NORTH FALLS OFFSHORE WIND FARM

**Natural England's comments on 7.15 Outline Horizontal Directional Drill Method
Statement and Contingency Plan [REP1-038]**

Planning Inspectorate Reference EN010119

18 March 2025

Figure 3-2 - landfall profiles

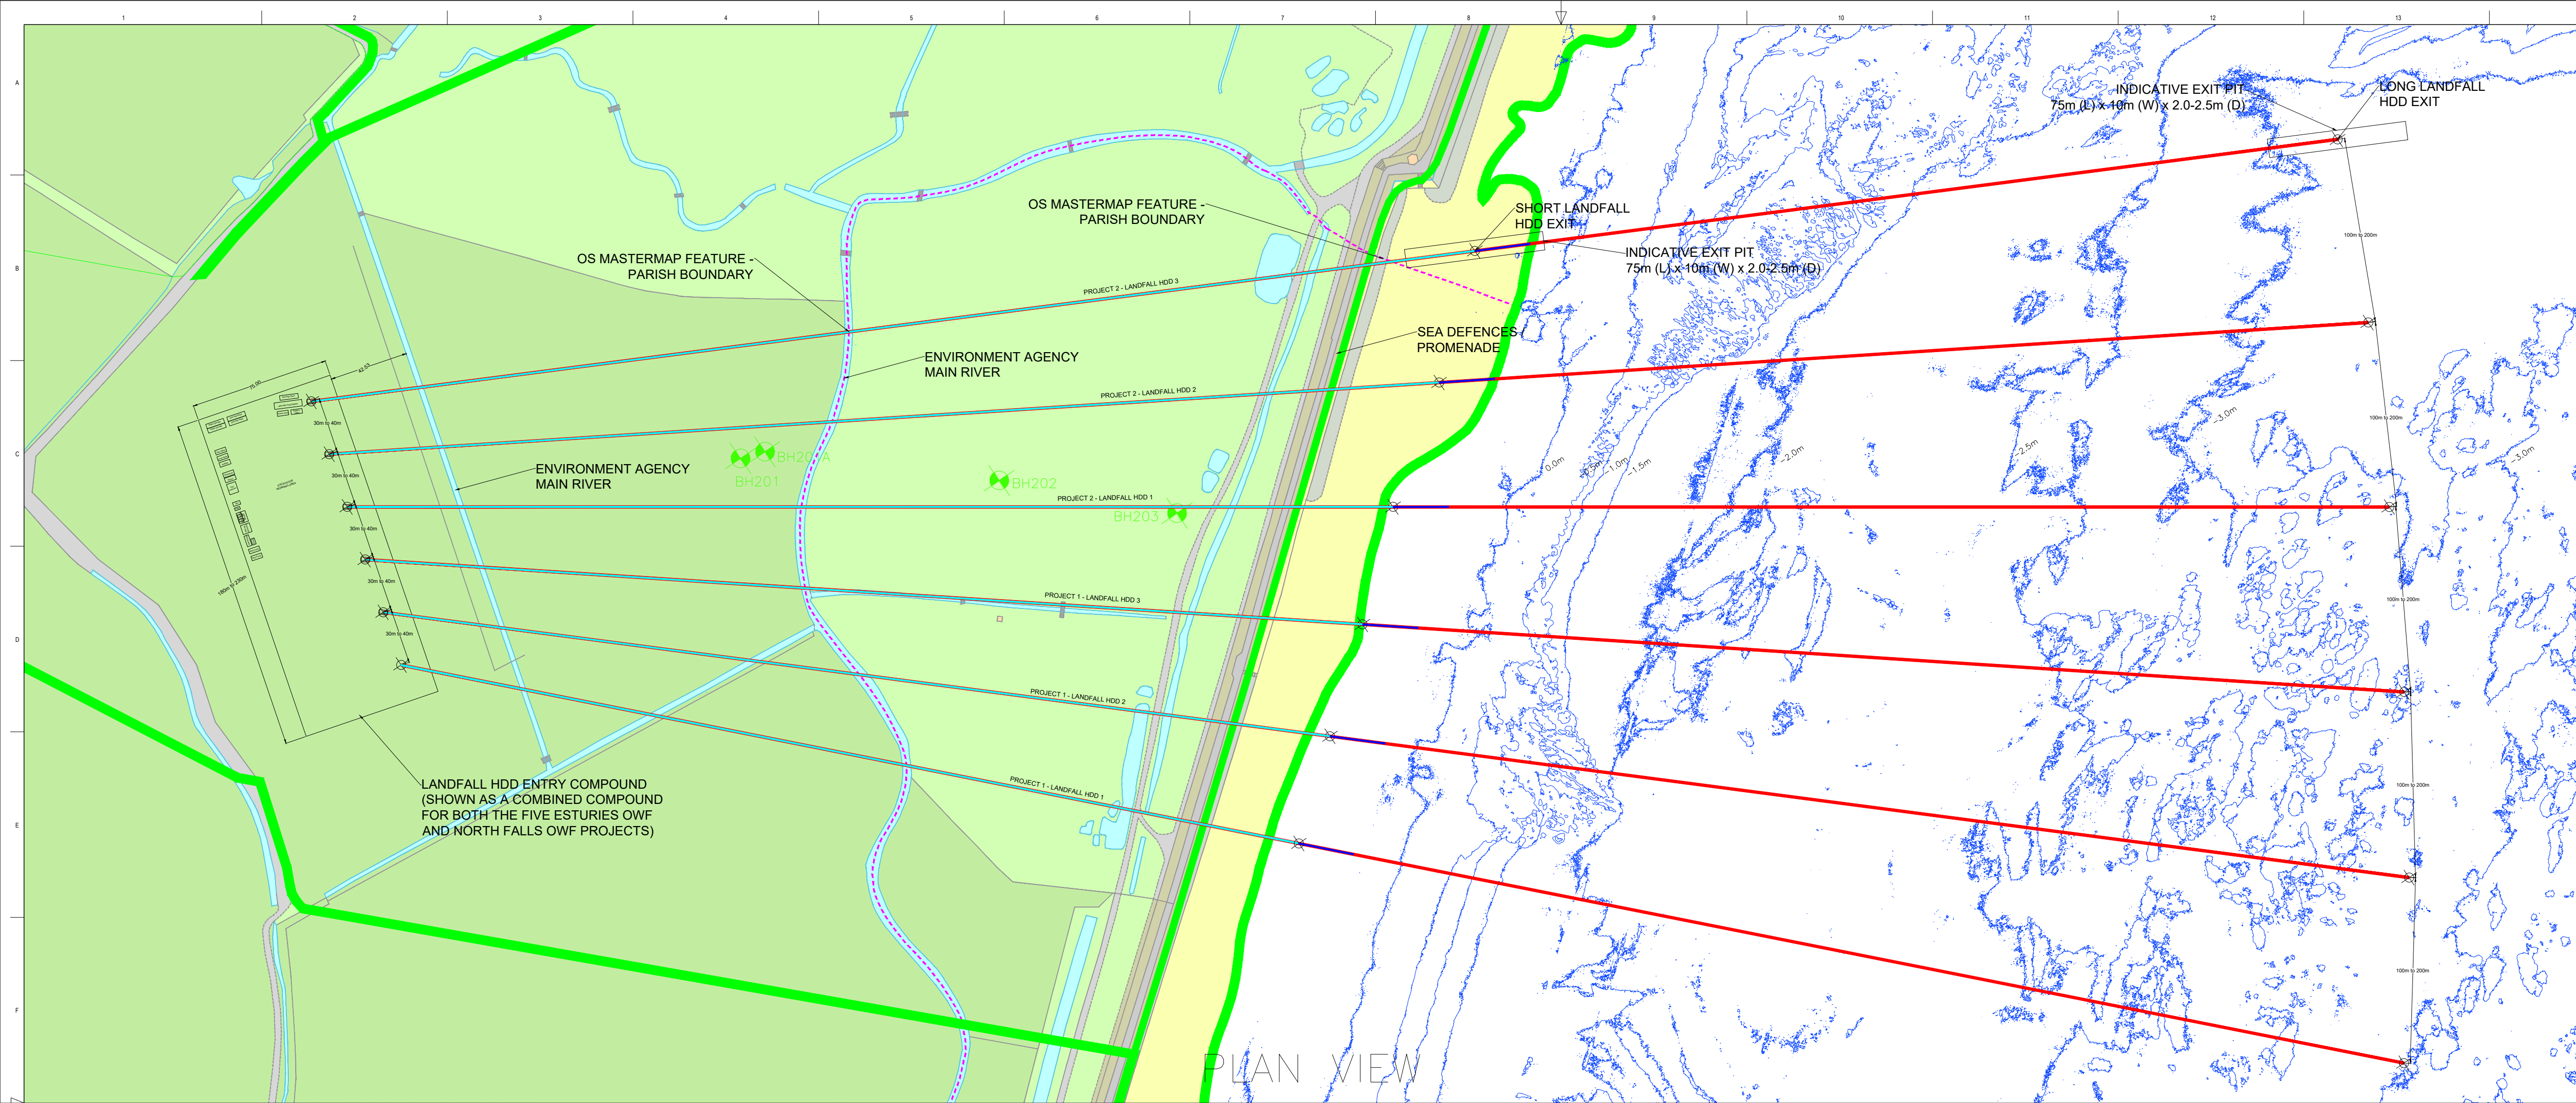
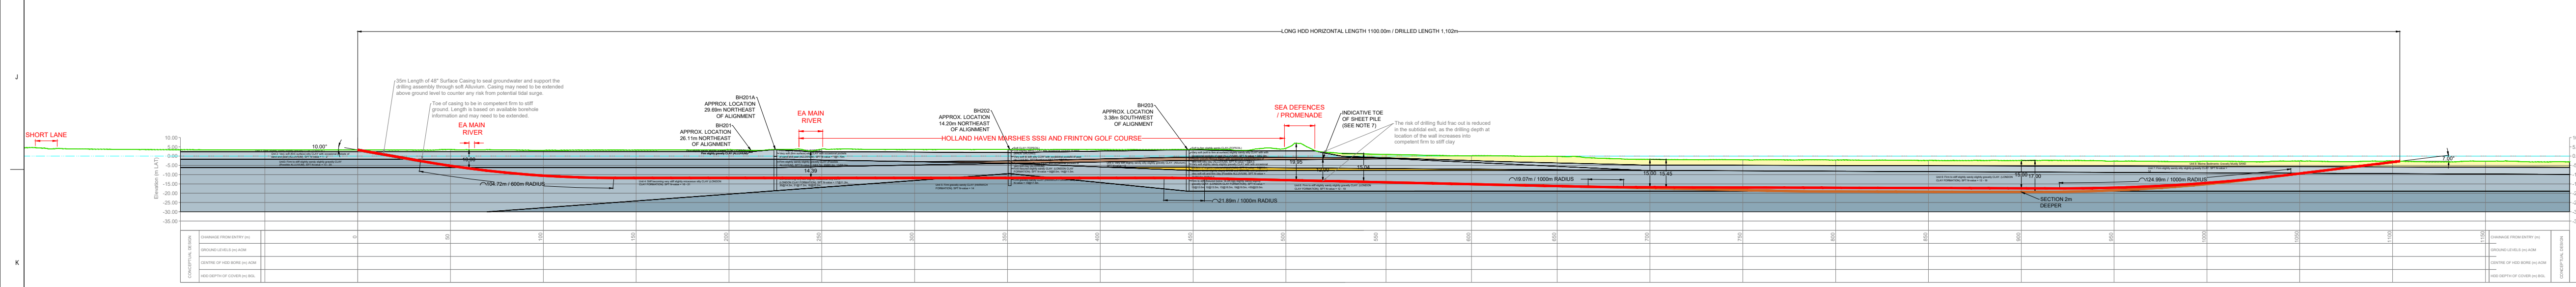
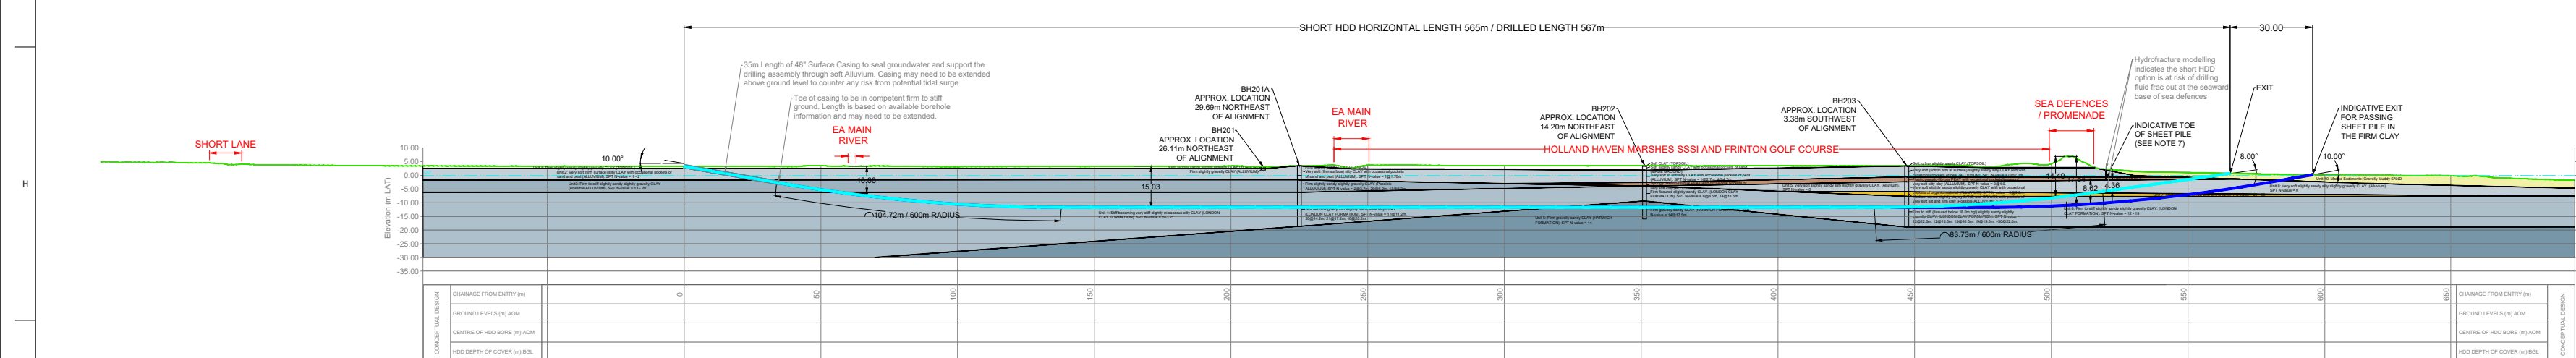
Document reviewed: [REP1-038] 7.15 Outline Horizontal Directional Drill Method Statement and Contingency Plan and [REP1-007] 2.6 Schedule of Mitigation (Rev 1)[List documents]			
NE Ref	Section	Key Concern and/or Update	Natural England's Advice to Resolve Issue
1	Figure 3.2	Natural England notes that key mitigation in the form of further coordination between North Falls and Five Estuaries could help further reduce the impacts. For example; this could include the first project to commence installation, installing the HDD ducts for both projects particularly at landfall	Natural England advises that the Applicant gives this further consideration.
2	Para. 107	Whilst Natural England welcomes the use of walkover surveys to detect bentonite on ground, Natural England is concerned about trampling of vegetation and invertebrate supporting habitat within Holland Haven Marshes SSSI and around Tendering Brook	Natural England advises that when agreeing the final plan that the number of walk overs, route/s taken and by how many people is agreed.
